Recommendation Report for Approval of Reserved Matters Following Outline Approval

REF NO:	Y/82/20/RES
LOCATION:	Land to the south of Ford Lane and East of North End Road Yapton BN18 0DS
PROPOSAL:	Approval of reserved matters following outline consent Y/80/16/OUT for 4.5ha of residential development comprising of 3.4ha of land for the erection of 100 No. dwellings (up to 30 (30%) affordable housing) together with 1.1ha of land set aside for public open space, strategic landscaping, 2.2ha of public open space, green corridors with vehicular access from Ford Lane & pedestrian/cycle access only from North End Road (resubmission following Y/19/20/RES). This application may affect the setting of listed buildings, affects the character & appearance of the Church Lane, Yapton Conservation Area & affects a Public Right of Way. This site falls within Strategic Site SP2 (Zero Rated).

Movement Plan

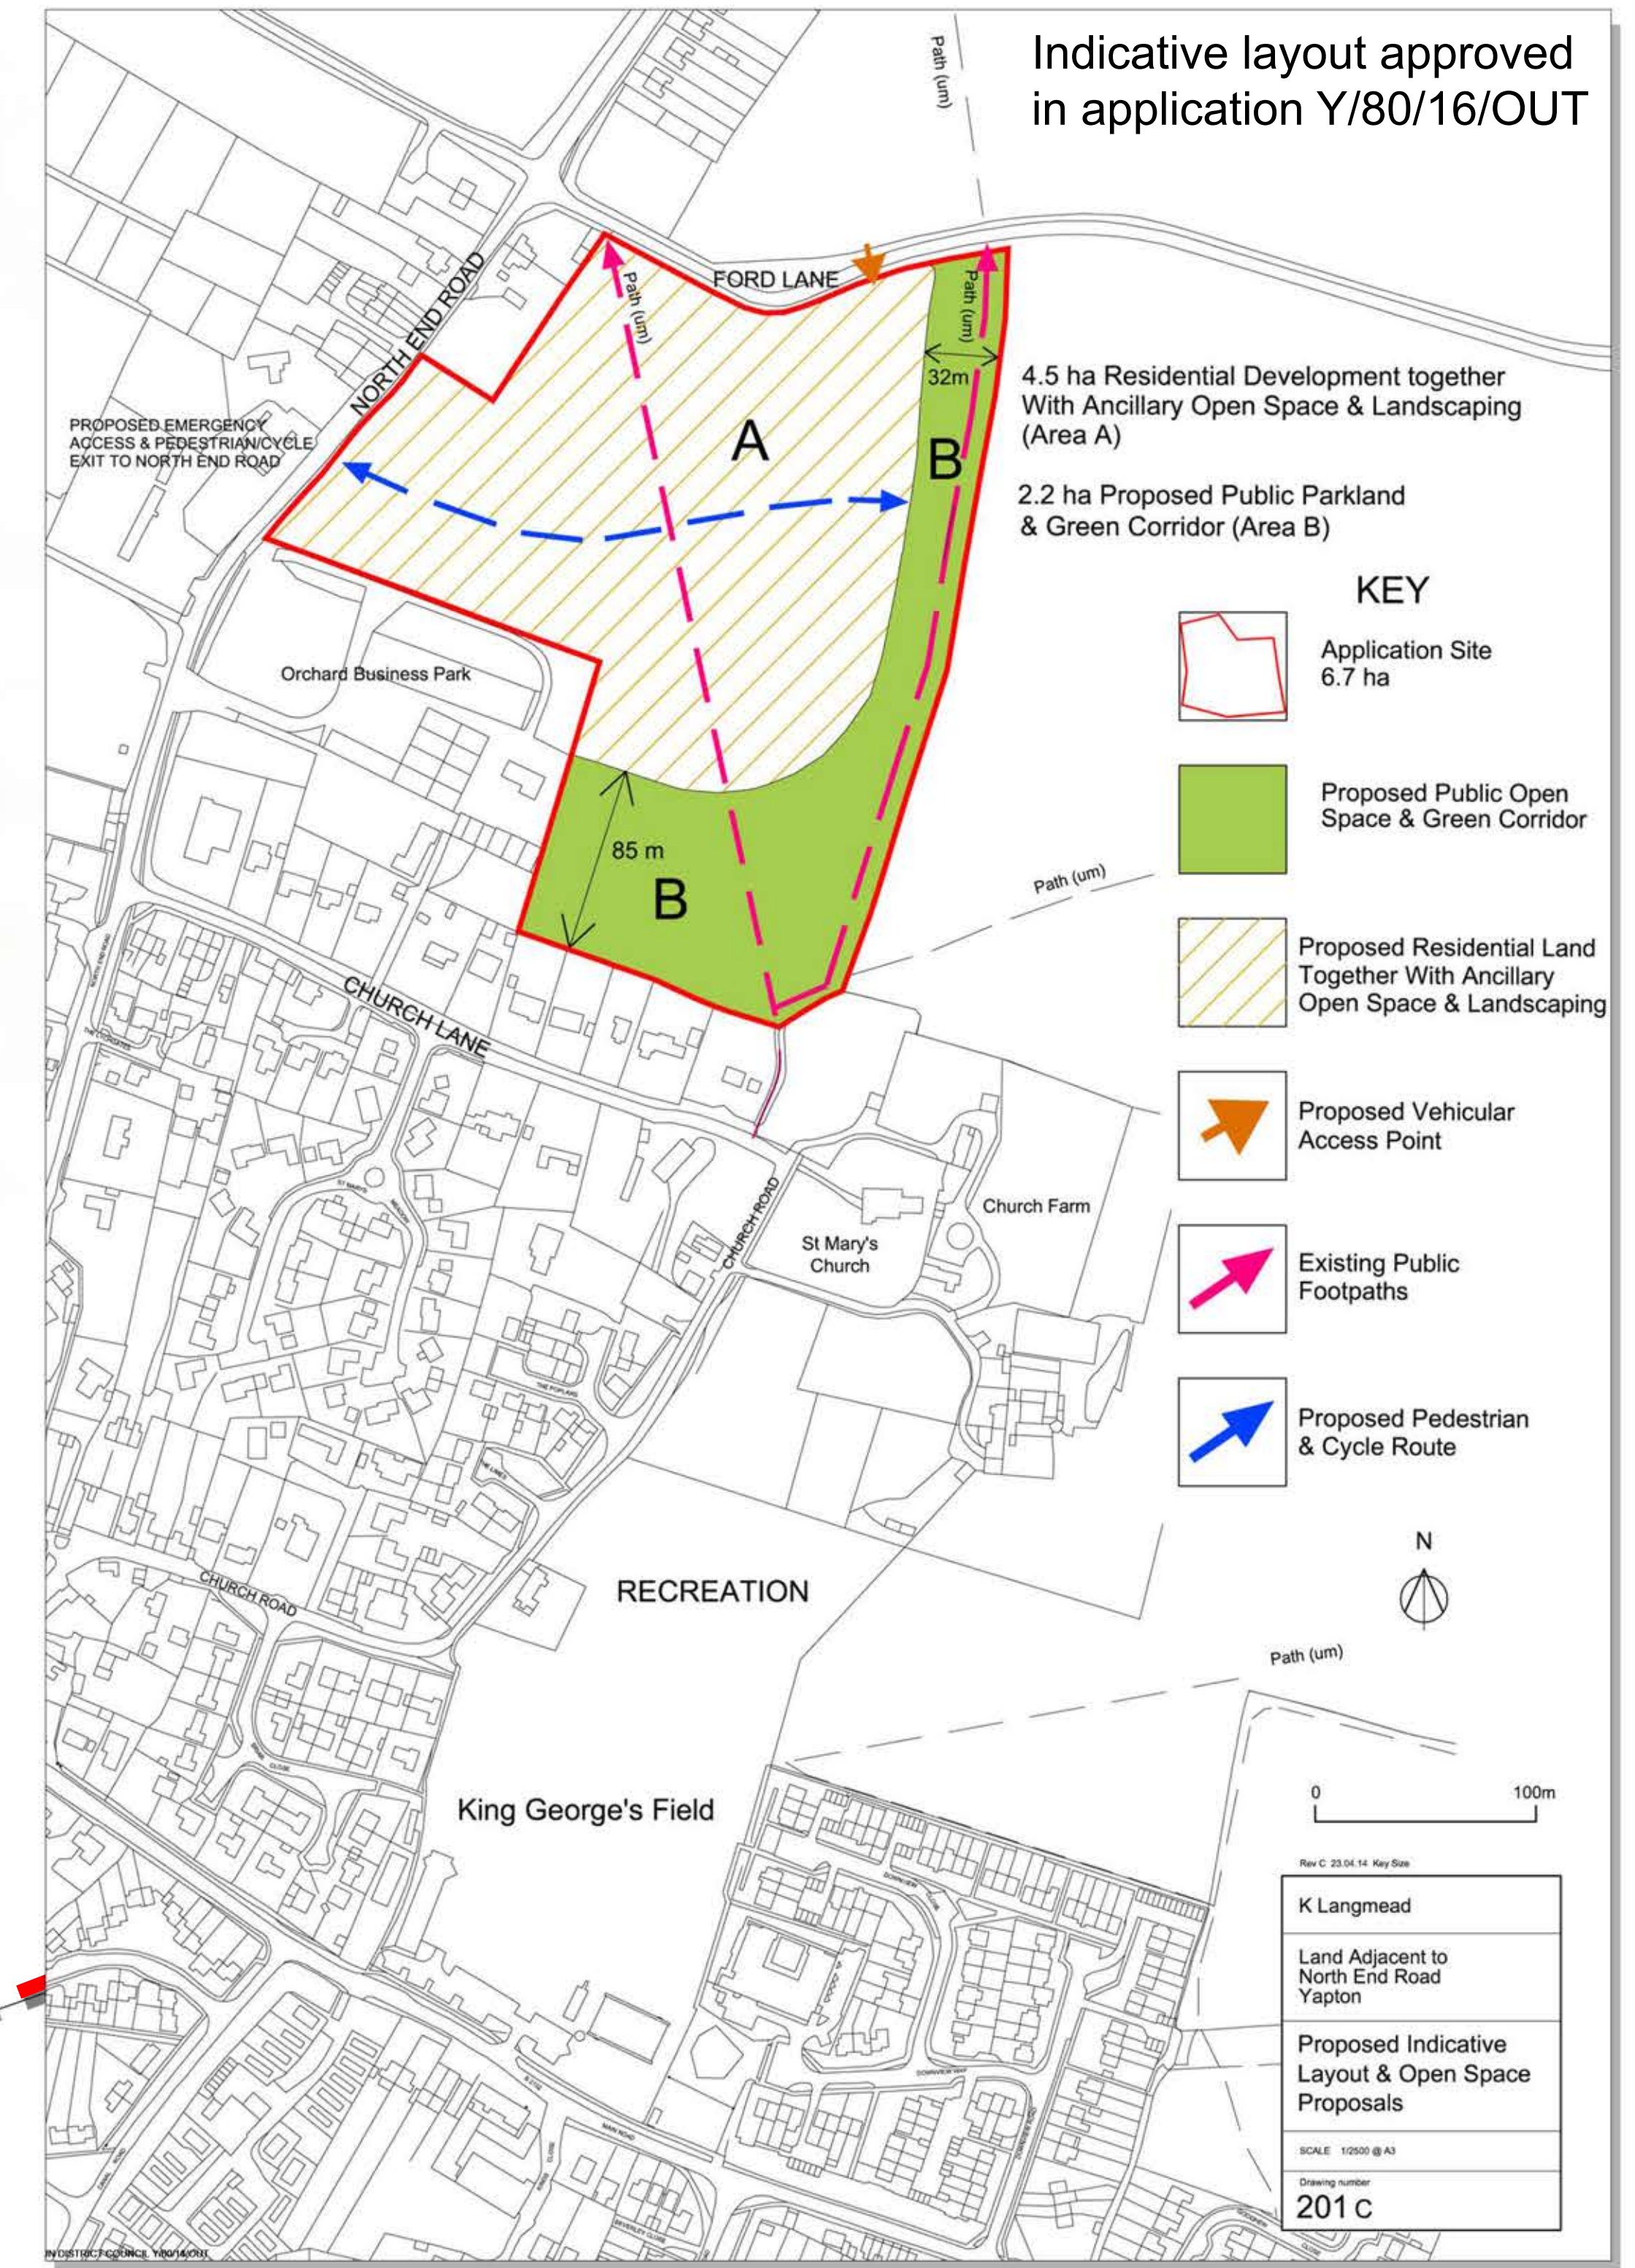
The submitted Movement Plan (Drawing No. 80) shows the line of a cycleway running east-west across the site from North End Road in the west to Ford Lane in the north east. The line of the proposed cycleway would link-up with the cycle link that would run from the new school in Ford and on through the strategic housing sites in Yapton and on southwards to the strategic allocation at Barnham / Eastergate / Westergate (known as BEW). The provision of this cycleway running east-west across the application site is supported by the Local Planning Authority and would be provided in a separate discharge of condition application for Condition 8 which would be submitted following the determination of this reserved matters application.
